Case Officer: Hansah Iqbal

Recommendation: Approval

Proposal: Incorporation of louvres, metal double doors, colour and finish to match adjacent, extension of external plant area, finish and materials to match existing, two new windows (proposed as non-material amendment to 22/01632/REM)

EXTERNAL MECHANICAL PLANT

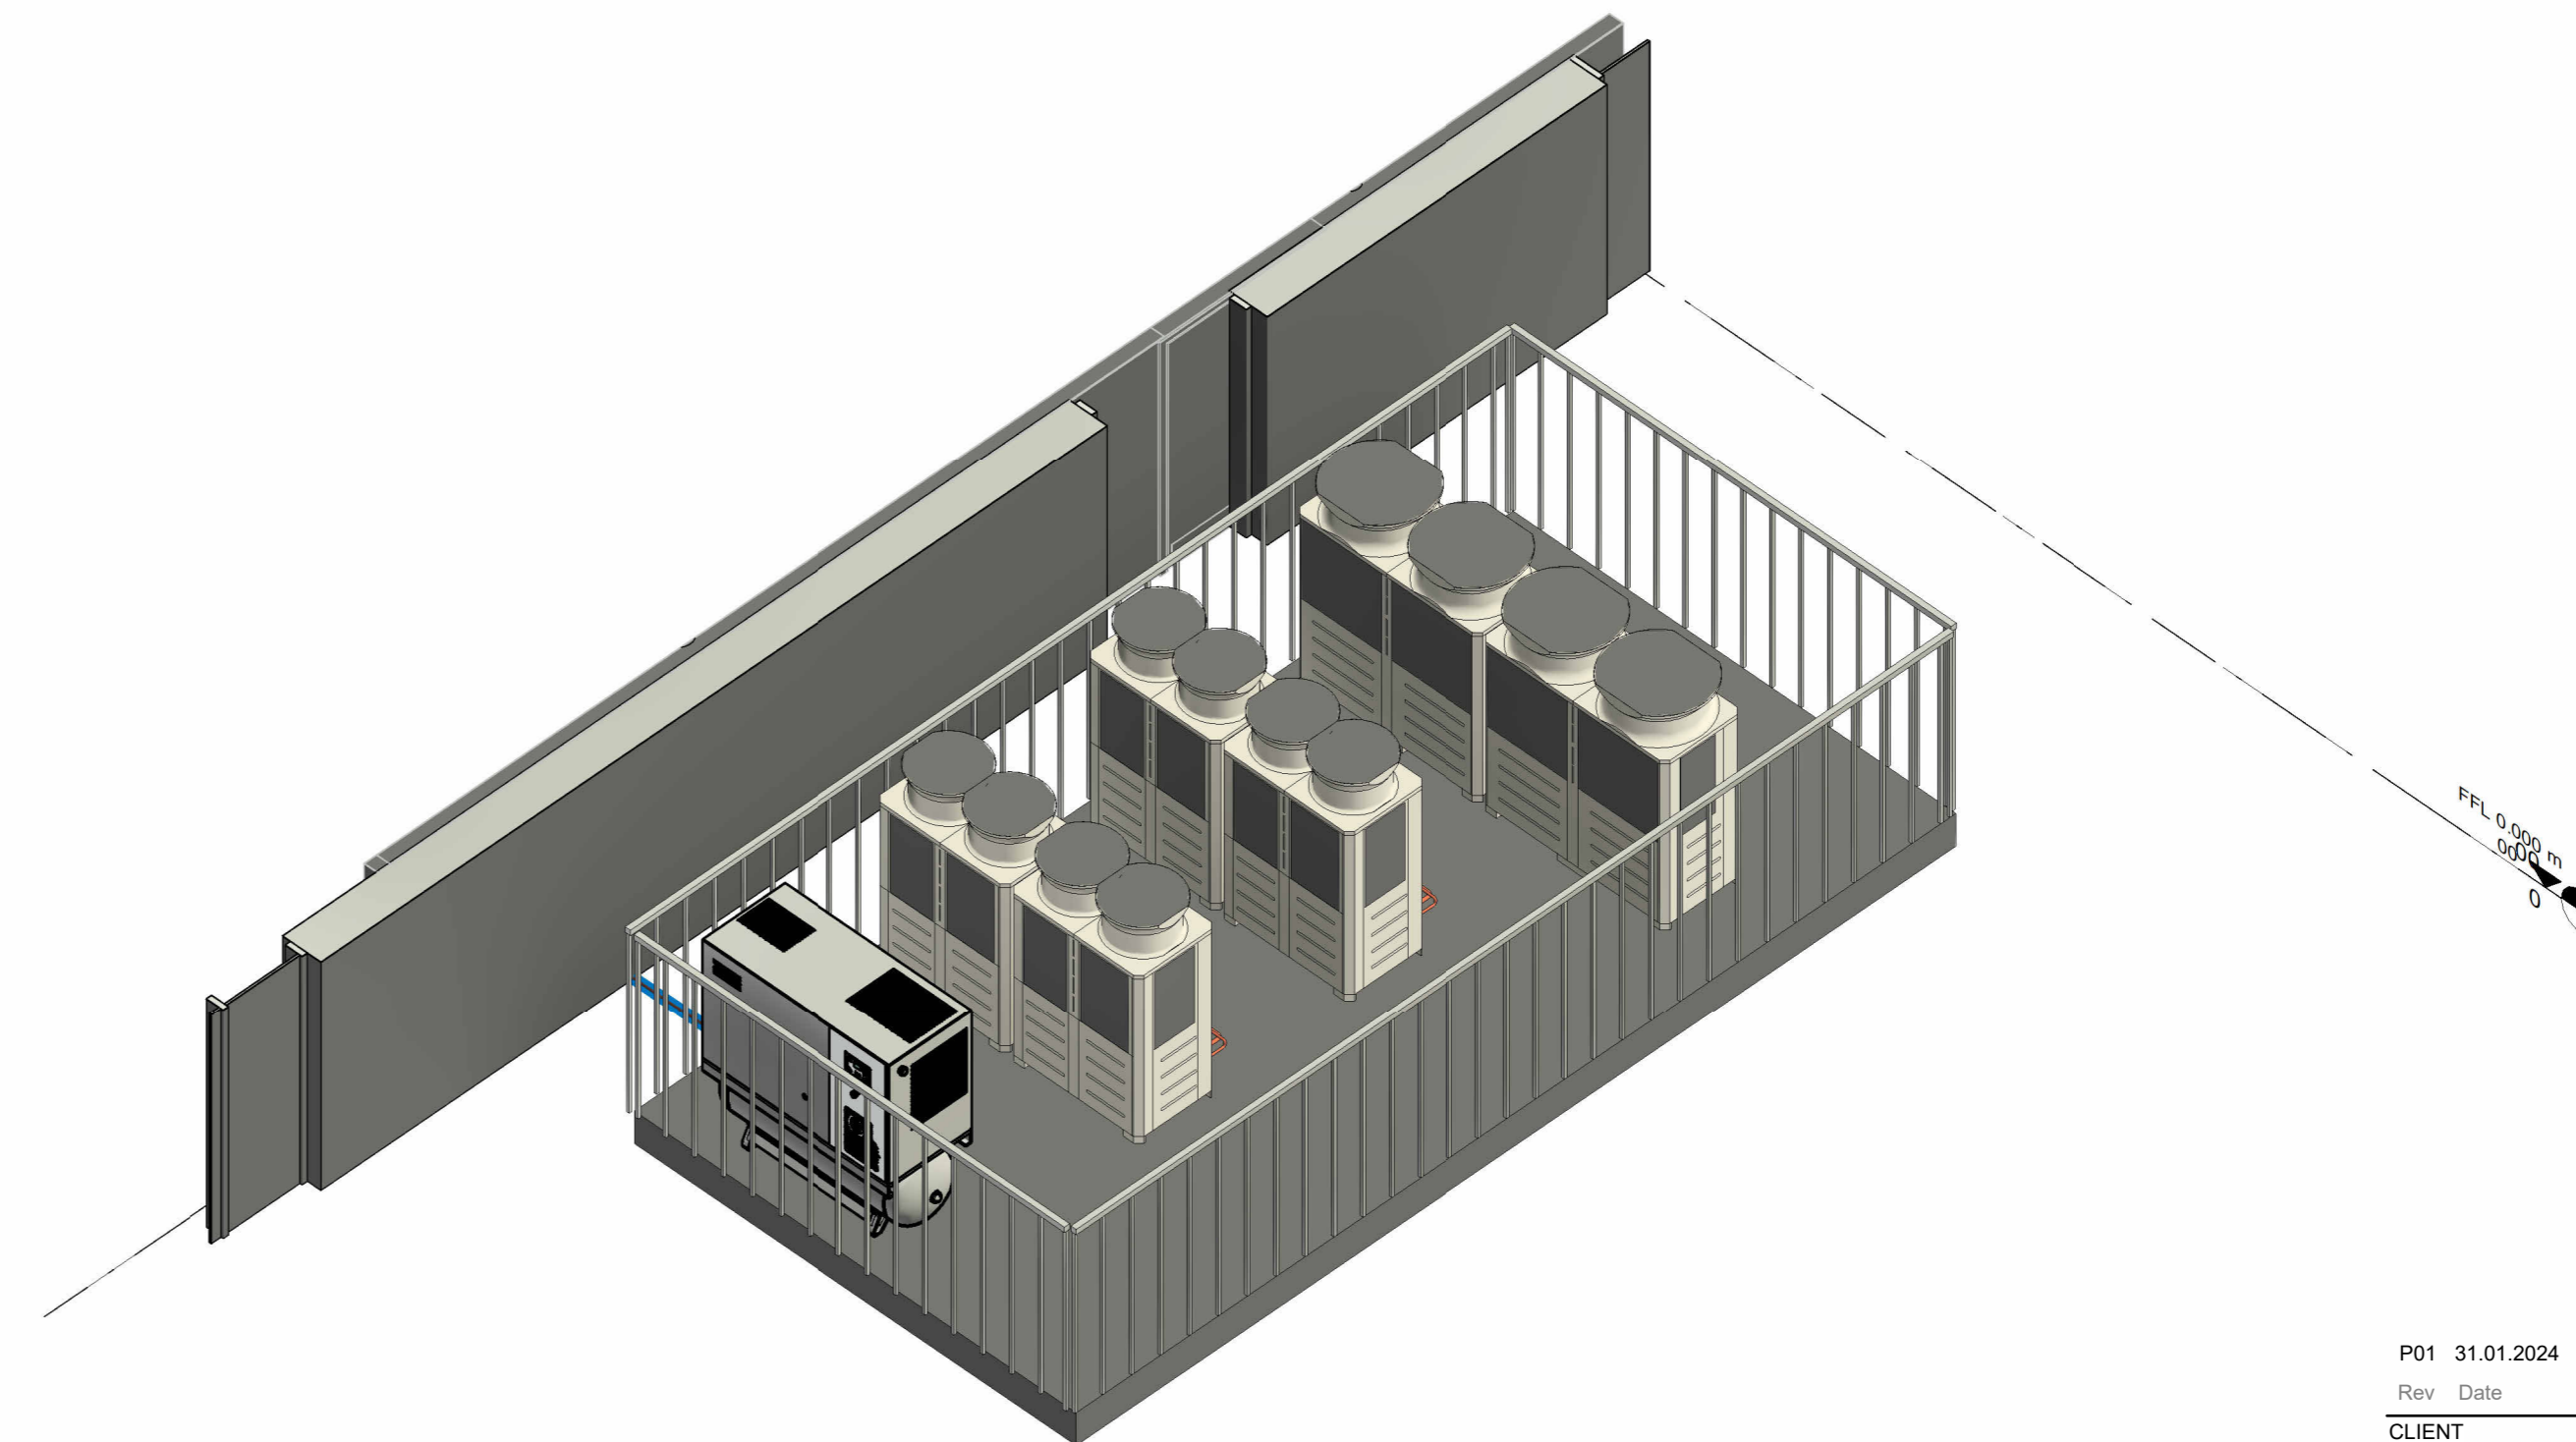
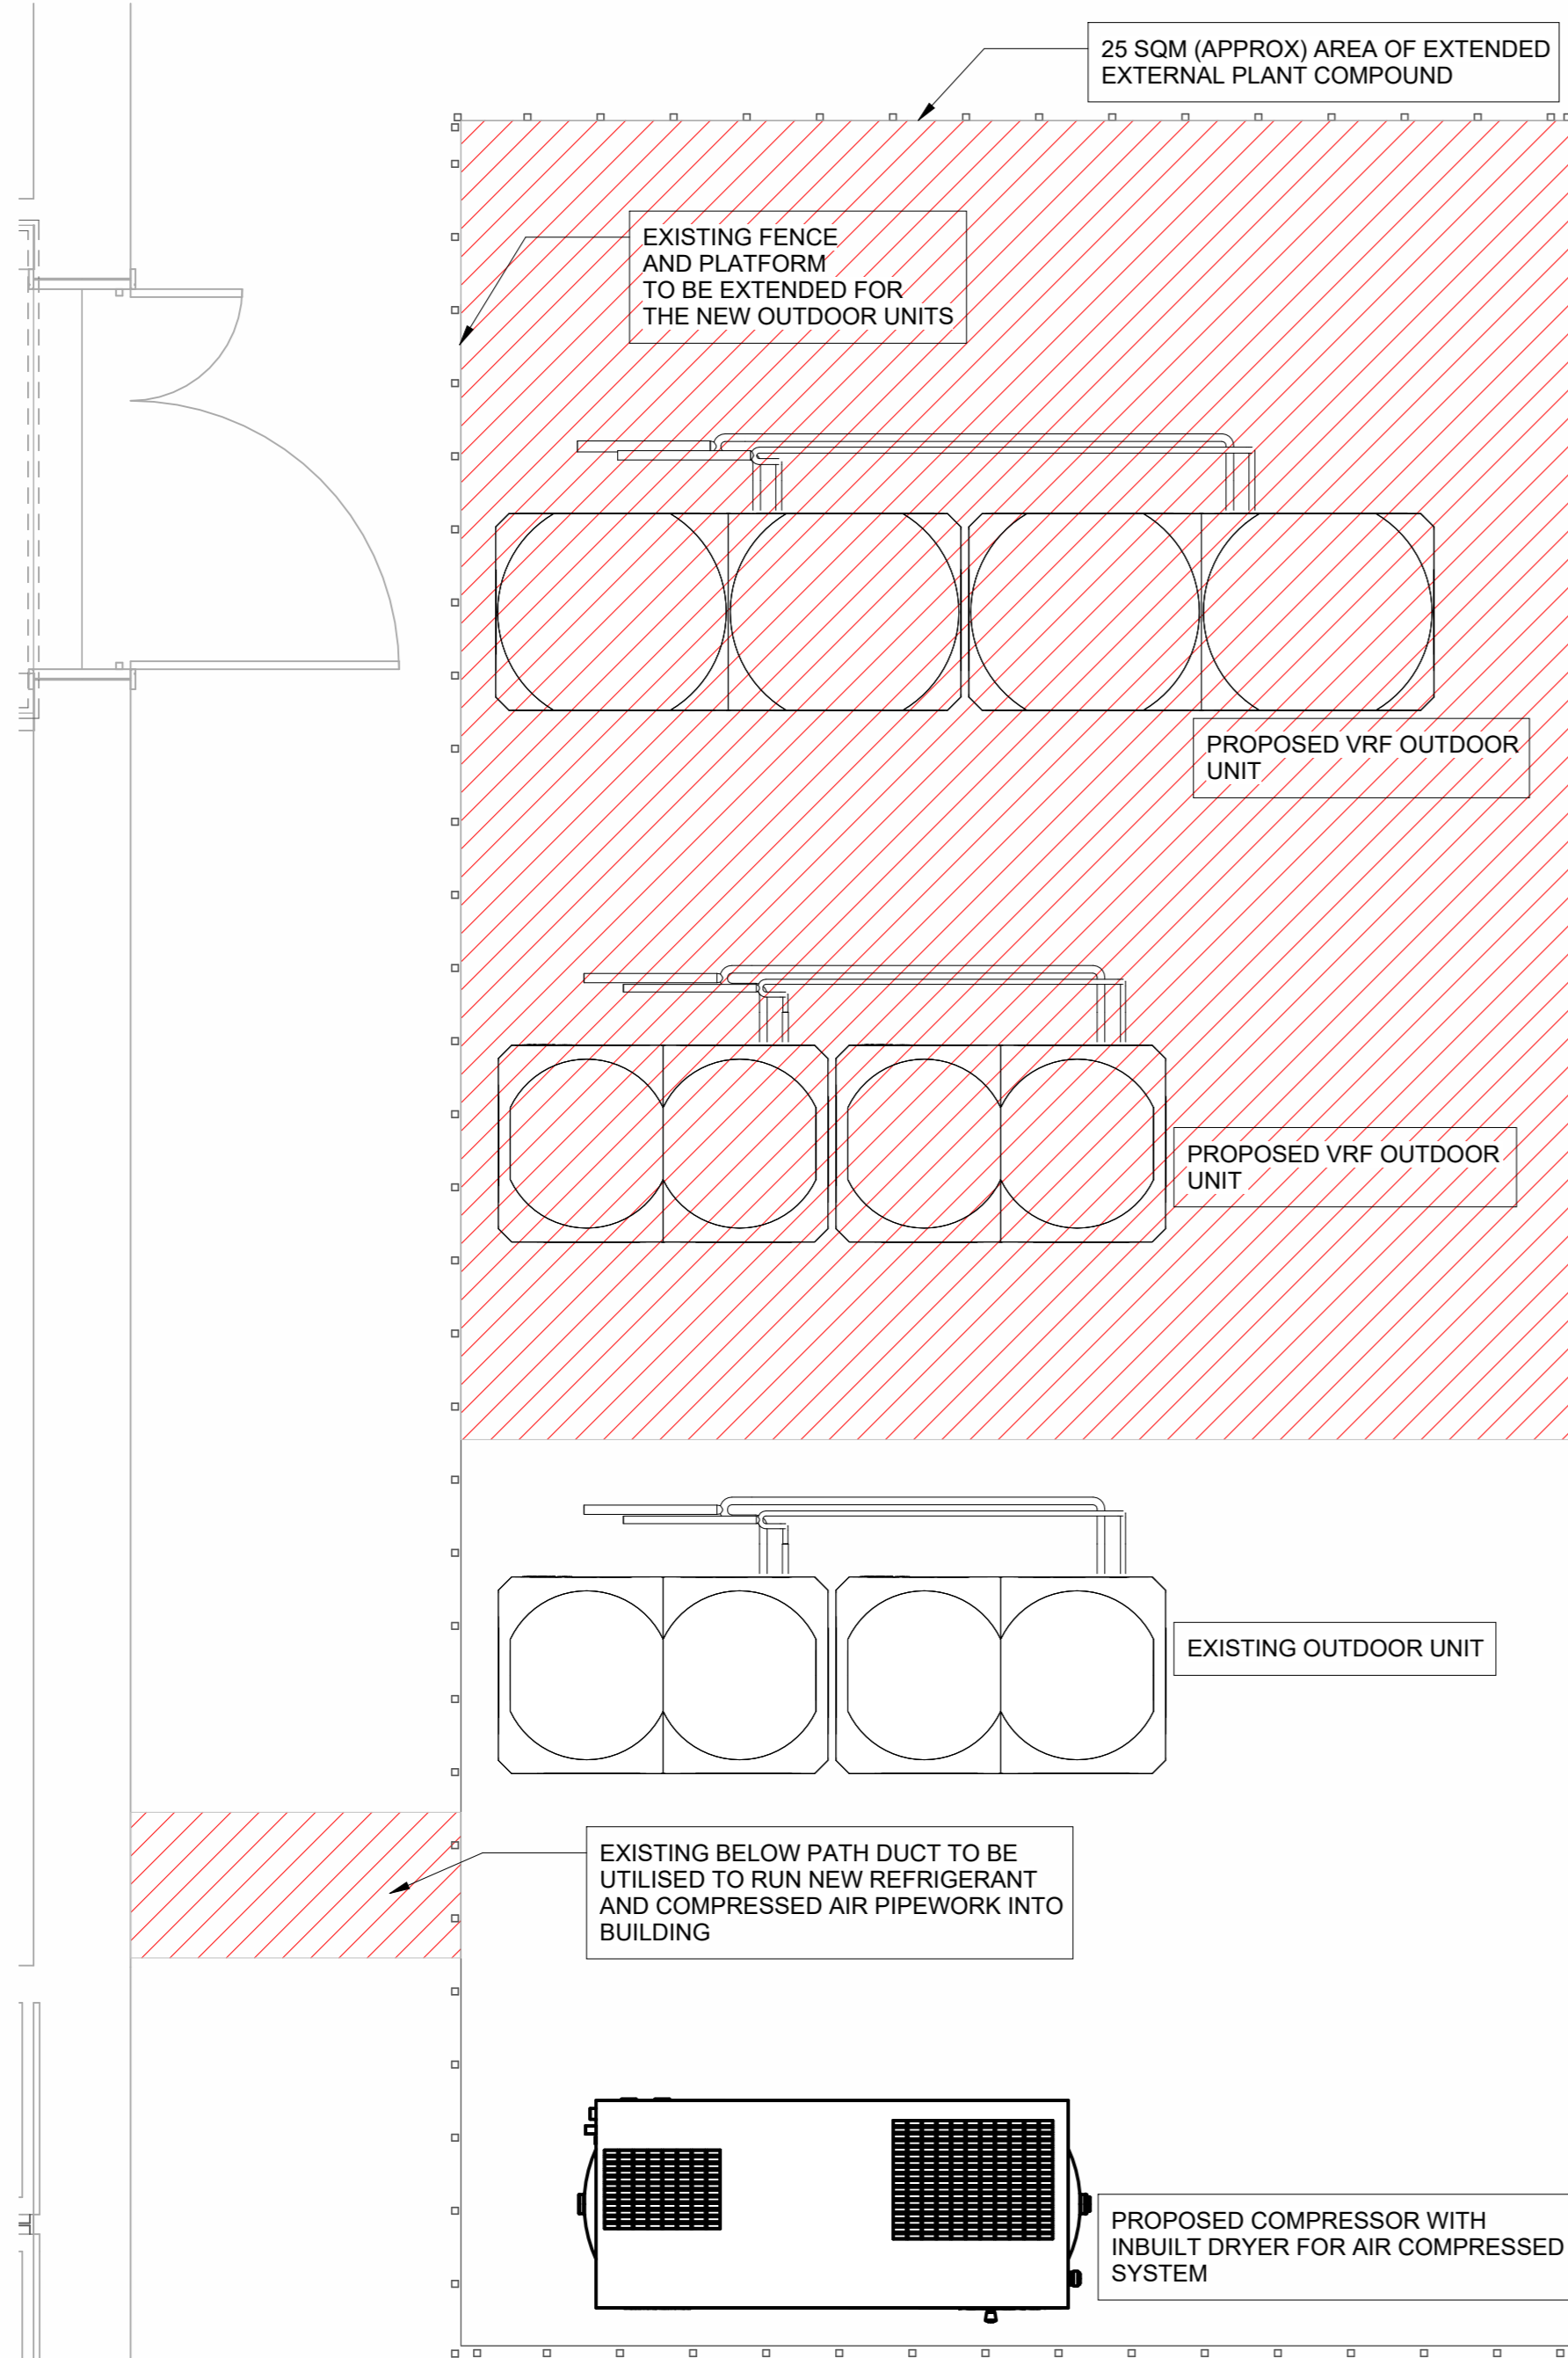
The enlargement of the external plan area would be more than double the size of the existing, however given the overall massing of the unit itself, it is considered to be relatively minor, the position is to the side and it remains an expected feature in a commercial environment such as this therefore would cause no greater harm than already approved.
